**WELWYN HATFIELD BOROUGH COUNCIL
EXECUTIVE DIRECTOR - PLANNING, PUBLIC PROTECTION AND GOVERNANCE**

DELEGATED APPLICATION

Application No: 6/2020/1211/HOUSE
Location: Northaw Place Coopers Lane Northaw Potters Bar EN6 4NQ
Proposal: Formation of new vehicular access following removal of existing close-boarded fence and erection of post and rail boundary fence and hedge with timber gate
Officer: Mr William Myers

Recommendation: Refused

Drg. No
747 / SP3A

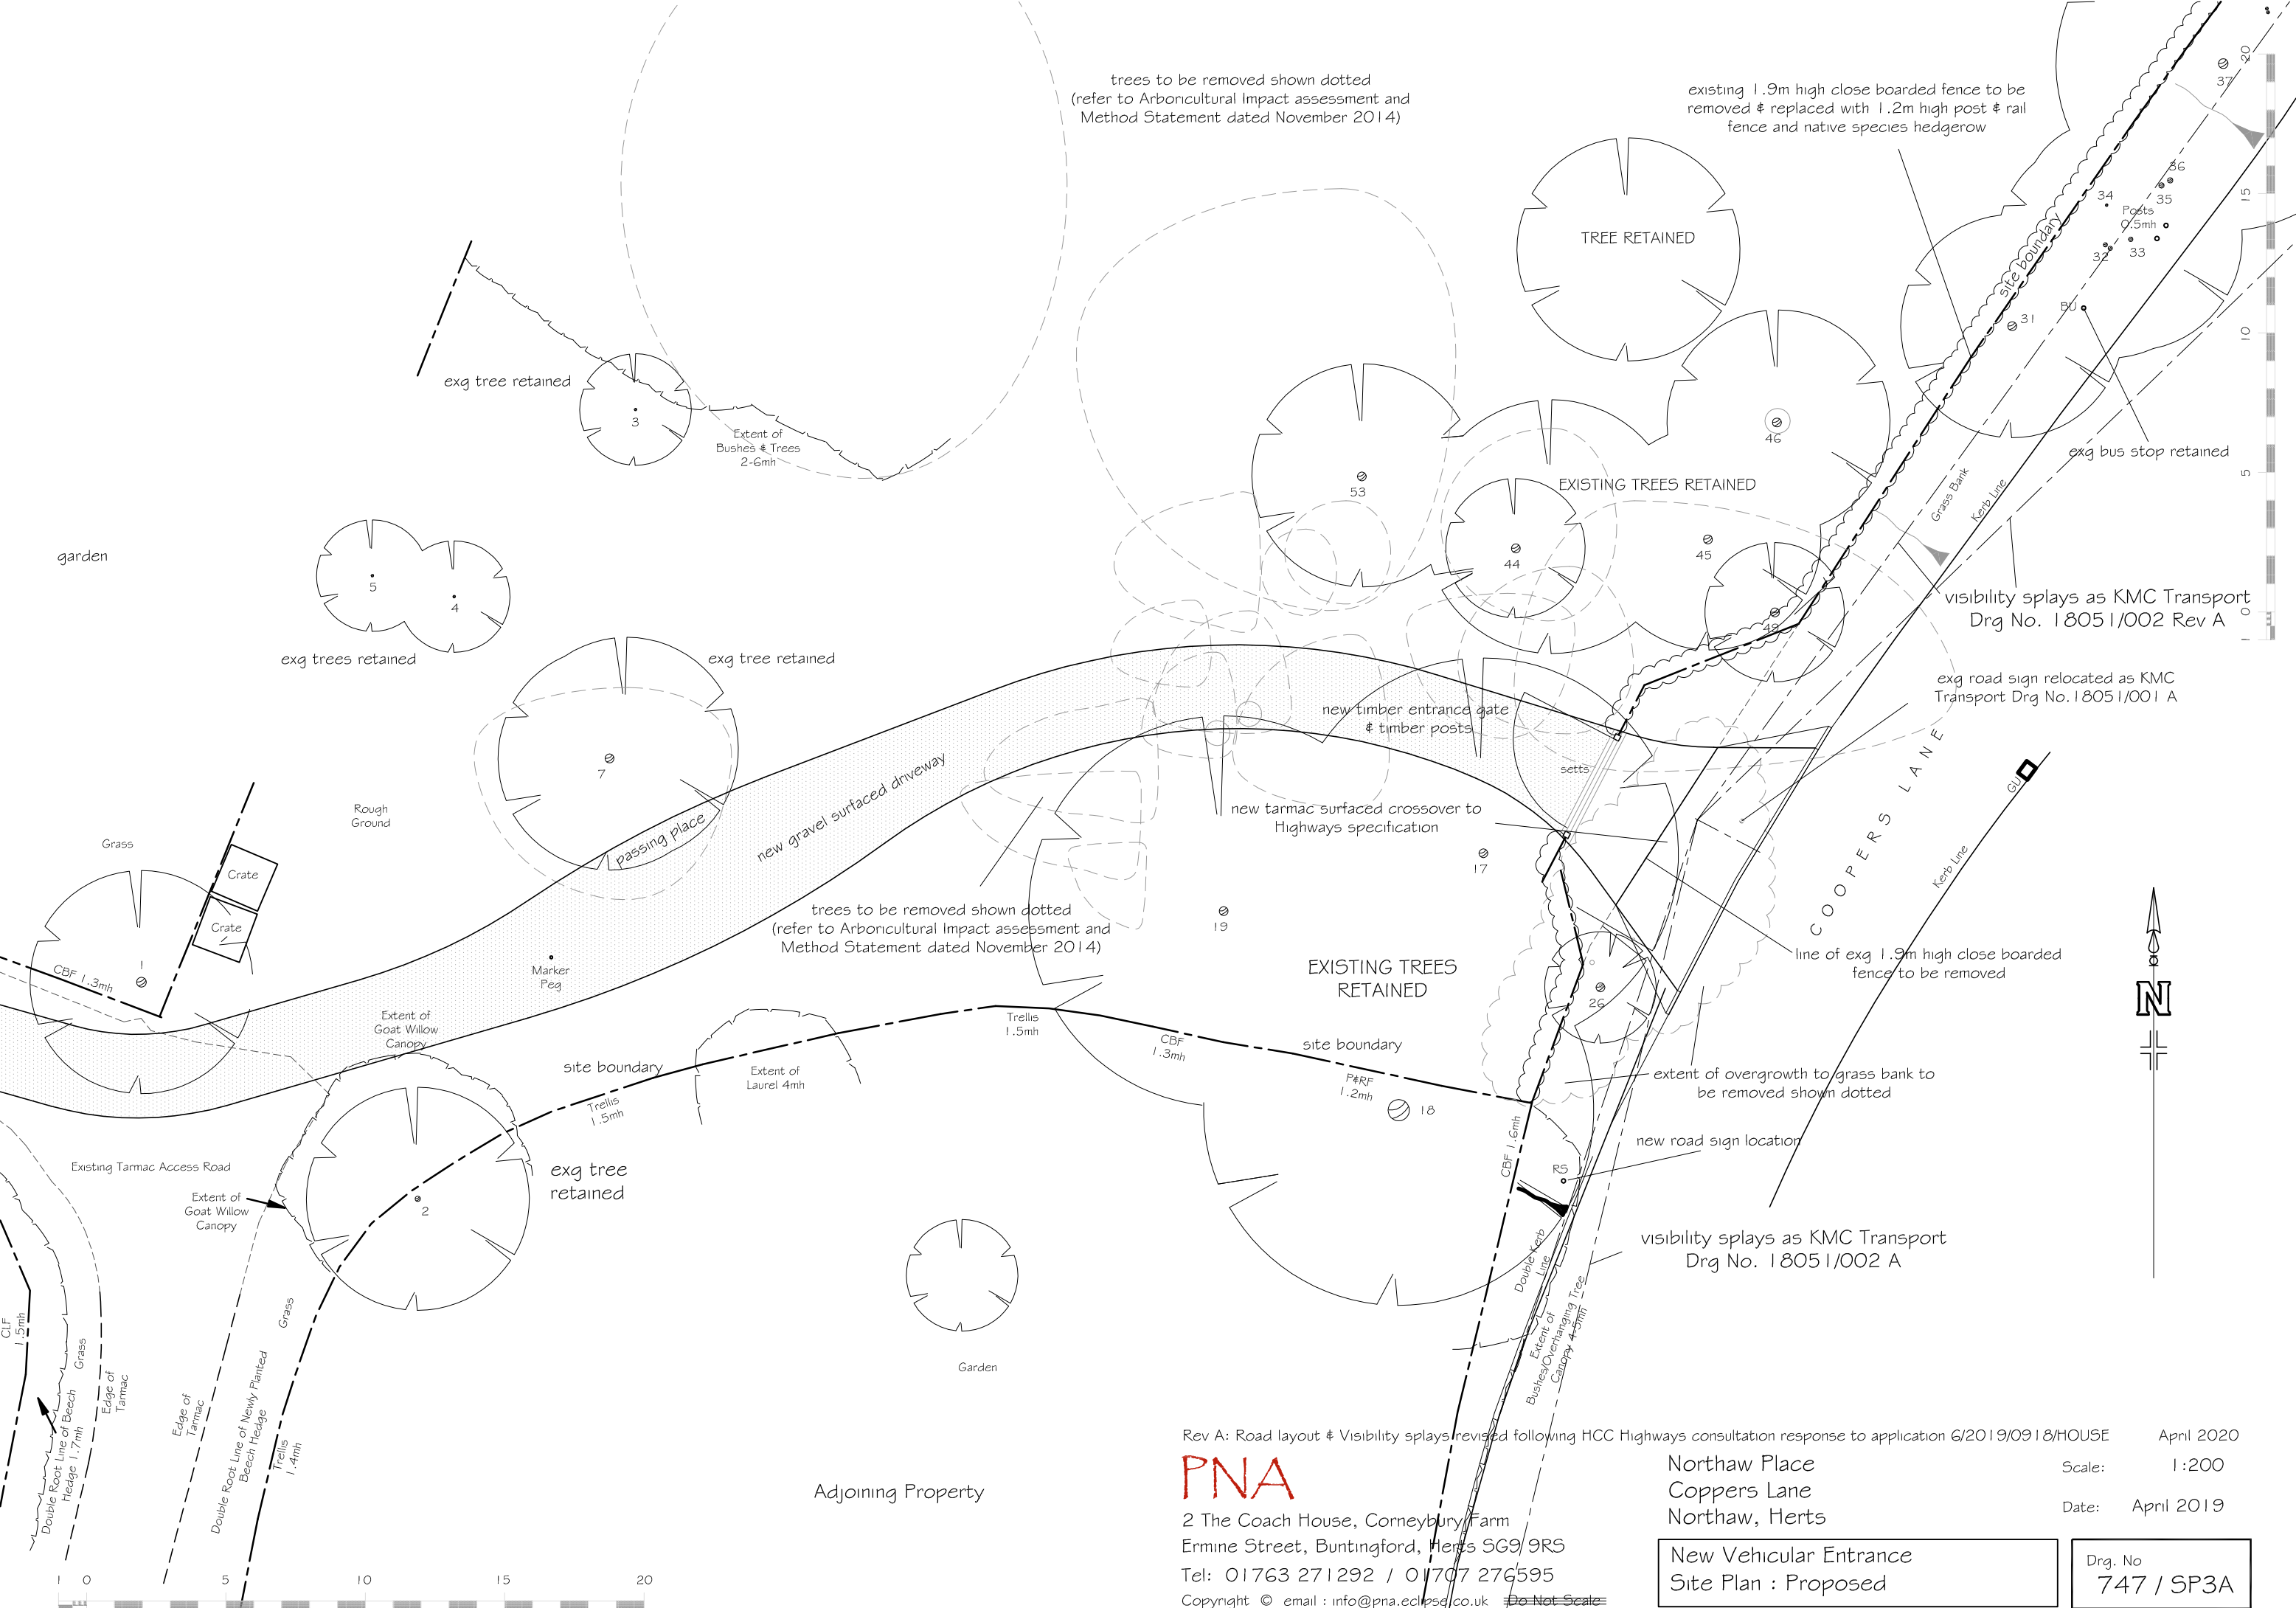
In this case, the development would introduce a prominent new point of access from the highway and result in an extensive area of hardstanding which would cross an area of undeveloped land which is currently free from any built form, with the exception of the boundary fence. The driveway would be visible from

public vantage points on Coopers Lane, through the gate and the breaks in the row of deciduous trees and hedgerow on the eastern side of the site. This would harm openness in a visual sense given that the proposal would result in a noticeable visual difference in how the Green Belt is experienced. As a consequence, the site would be noticeably more developed than the existing situation and as such would fail to preserve the openness of the Green Belt.

<p>The site is within the Northaw Common Parkland Landscape Character Area having regard to the District Plan Policy RA10. The Northaw Common Parkland Landscape Area is characterised by parkland features, with landscapes that have been created through the historic development of these parklands and estates. The area is predominantly rural in character with formal parkland and estate entrances being the norm. The recommended strategy for the area includes ensuring that historic hedged field boundary patterns are retained and that any new planting improves the character of the area. The NPPF states that developments should be sympathetic to landscape setting.</p> <p>The proposed development would create a new entrance within an existing defined boundary treatment which would negatively alter the character of this section of Coopers Lane by punching a hole in this defined mature boundary treatment along this part of Coopers Lane. The gated entrance to the application site from Coopers Lane would give views into the site and the hardstanding that would be create to facilitate the new use of this land as a residential driveway. Although no objection is raised to the proposed replacement fence, it is considered this would only represent a modest benefit, which can be attached only limited weight.</p> <p>Further to the above, it is therefore considered that the proposed use and associated hardstanding would not be in keeping with its surroundings and would be visually intrusive and out of keeping with character of the area. The proposal is therefore, contrary to Policies D1, D2 and RA10 of the Welwyn Hatfield District Plan 2005.</p>

1. By virtue of its scale and appearance, the development spreads built form into what was previously undeveloped land and, as such, fails to assist in safeguarding the countryside from encroachment, contrary to paragraph 134 of the National Planning Policy Framework 2019. The formation of a driveway would also harm the openness and the appearance of the Green Belt in this location. The proposal is therefore inappropriate development in the Green Belt. Very special circumstances to outweigh the harm to the Green Belt do not exist as the harm to the Green Belt and other harms, are not clearly outweighed by other considerations. Accordingly, the development is contrary to Policies GBSP1 and GBSP2 of the Welwyn Hatfield District Plan 2005; Policy SP3 and SADM34 of the Council's Draft Local Plan Proposed Submission 2016; and the National Planning Policy Framework 2019.

2. The development of this site is considered to result in an unacceptable erosion of the demonstrable physical attributes within the Landscape Character Area and would neither conserve, maintain, enhance nor strengthen the character of the wider surrounding area. As such, the proposal is not considered to comply with Policies D1, D2 and RA10 of the Welwyn Hatfield District Plan 2005; Policies SP9 and SADM16 of the Council's Draft Local Plan Proposed Submission 2016; and the National Planning Policy Framework 2019.

3. Insufficient information has been provided as part of this application to enable the Local Planning Authority to fully assess the highway risks arising from the proposed development and to demonstrate that the development would not result in an unacceptable impact on highway safety. Accordingly the proposed development poses a risk to highway safety, contrary to proposed development would not accord
